# CITY OF ALBUQUERQUE

**Re: APS Montgomery Complex,  
3315 Louisiana Blvd, 8710  
Request for Certificate of Occupancy  
Transportation Development Final Inspection  
Engineer's/Architect's Stamp dated 4-25-17 (G18D048)  
Certification dated 2-5-19**

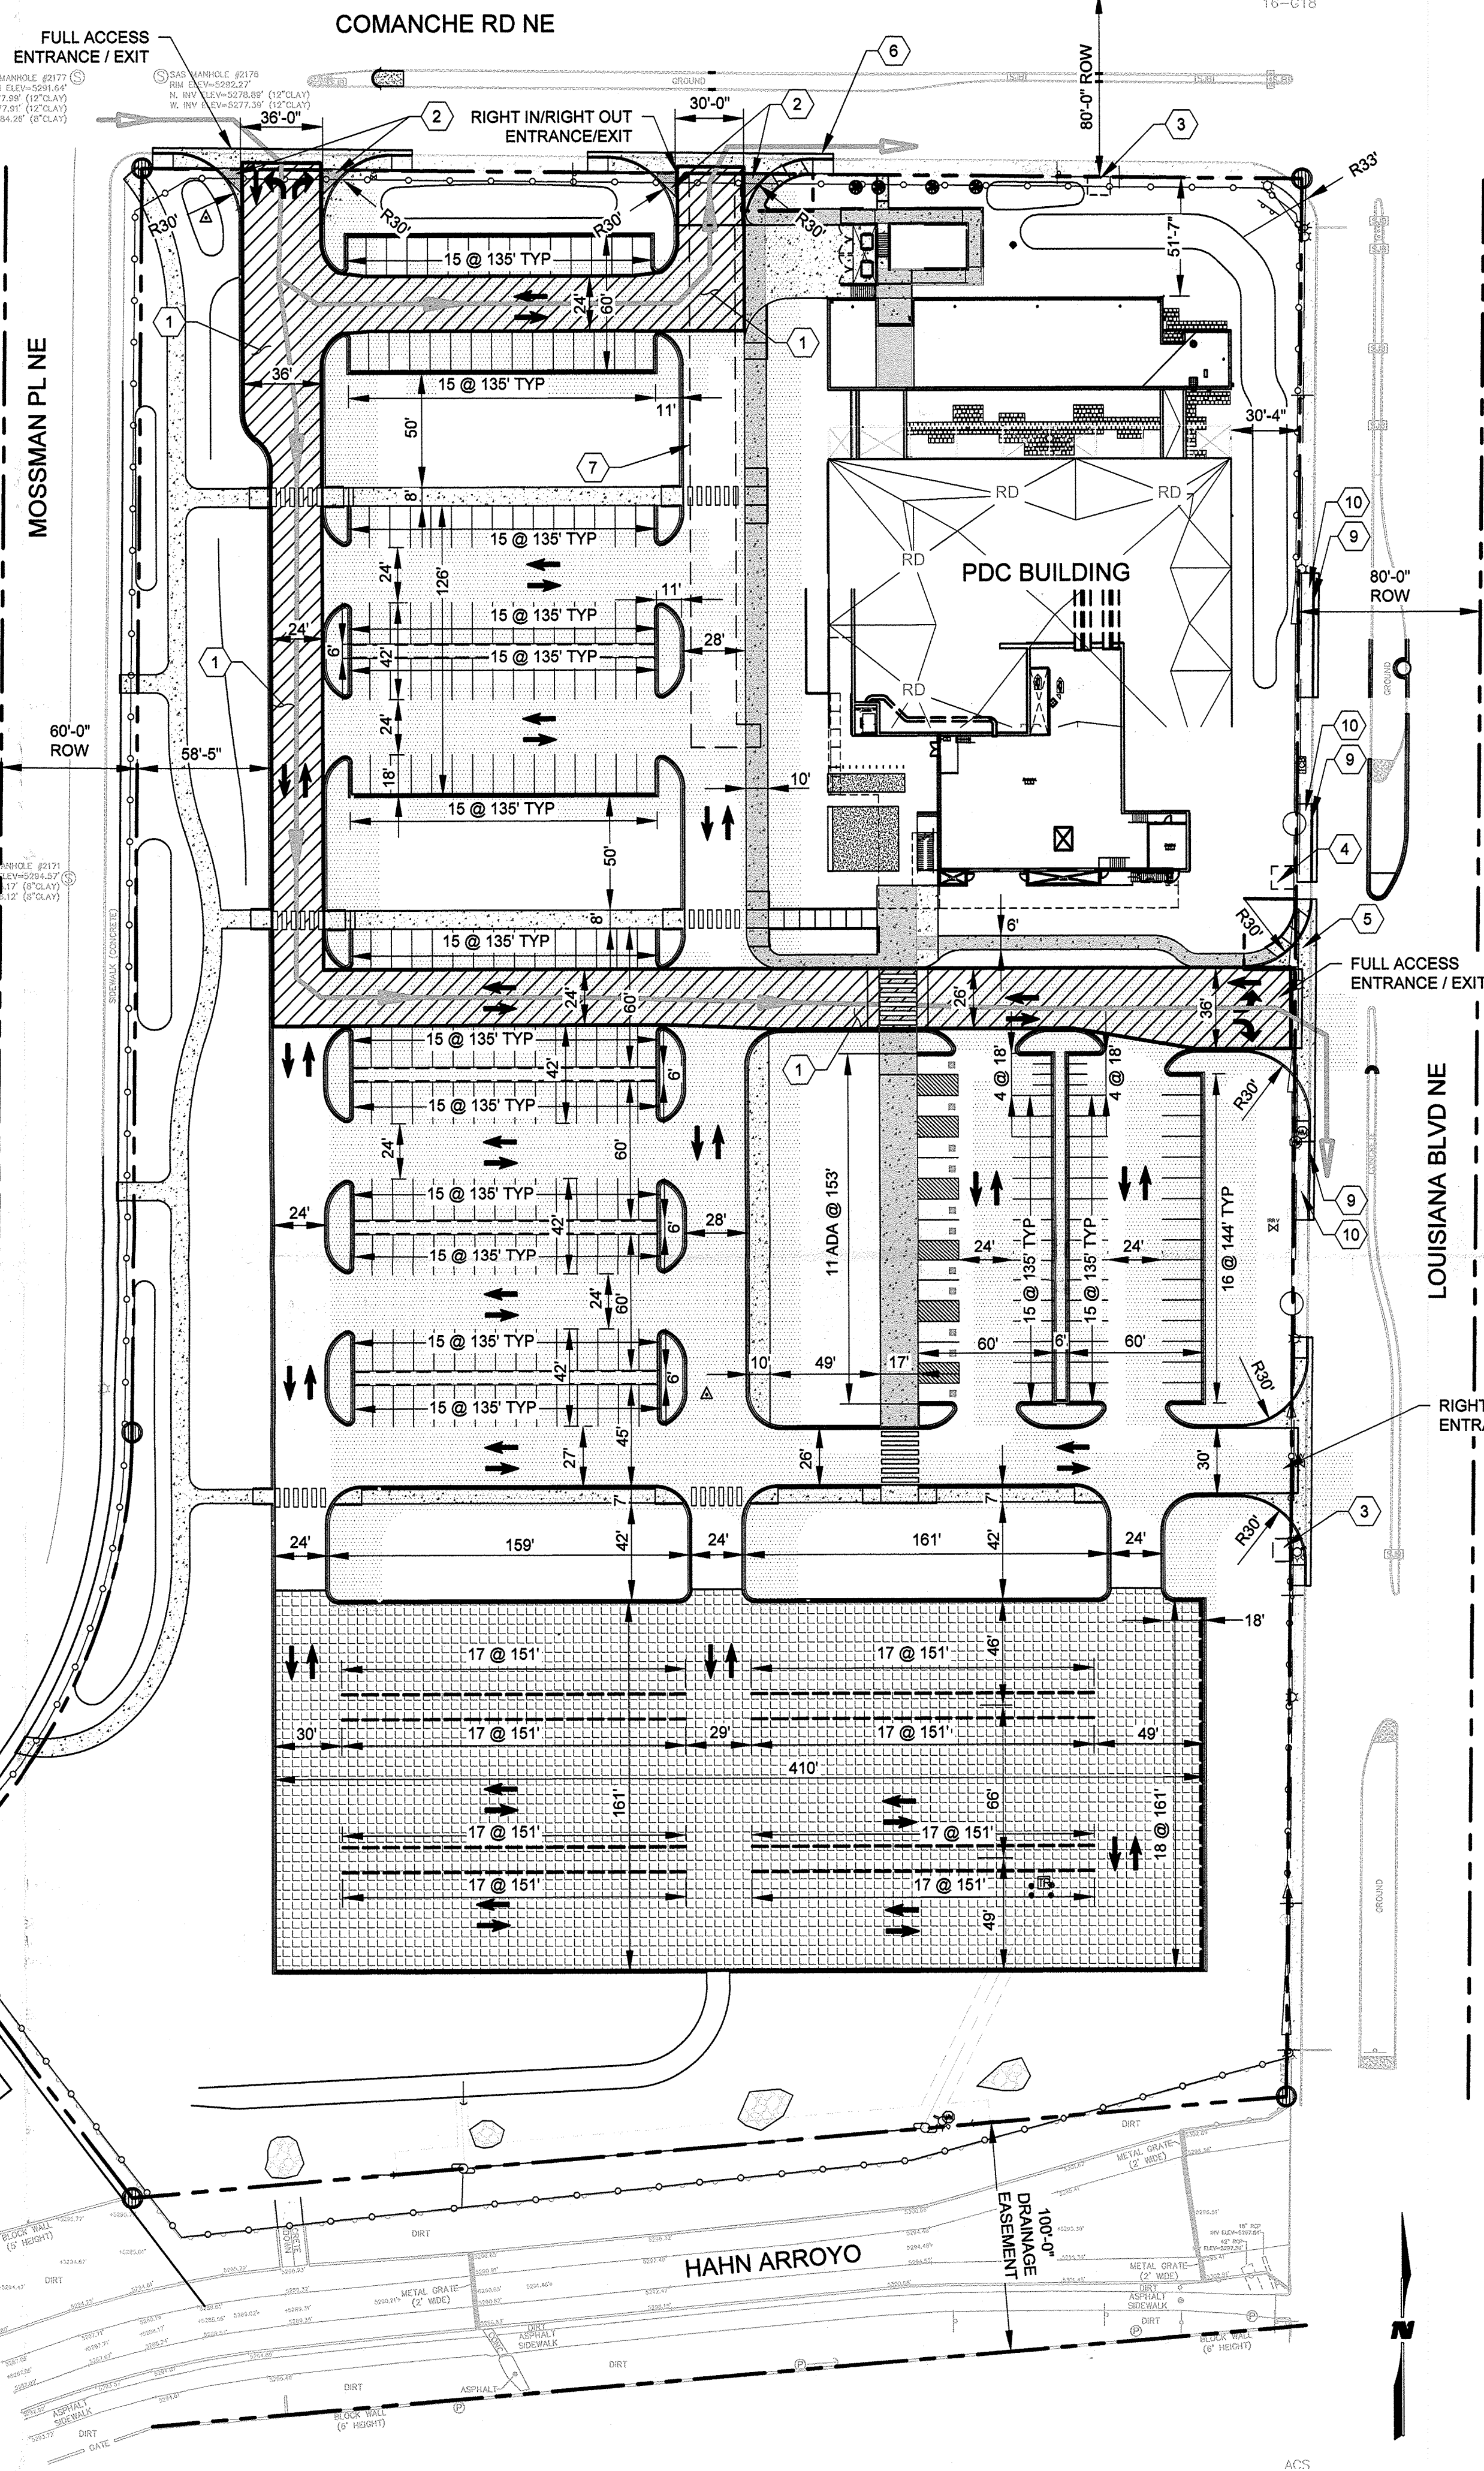
- Please add Motorcycle Signs.

- Please remove bollards or close curb cut at SE corner of Louisiana next to channel.
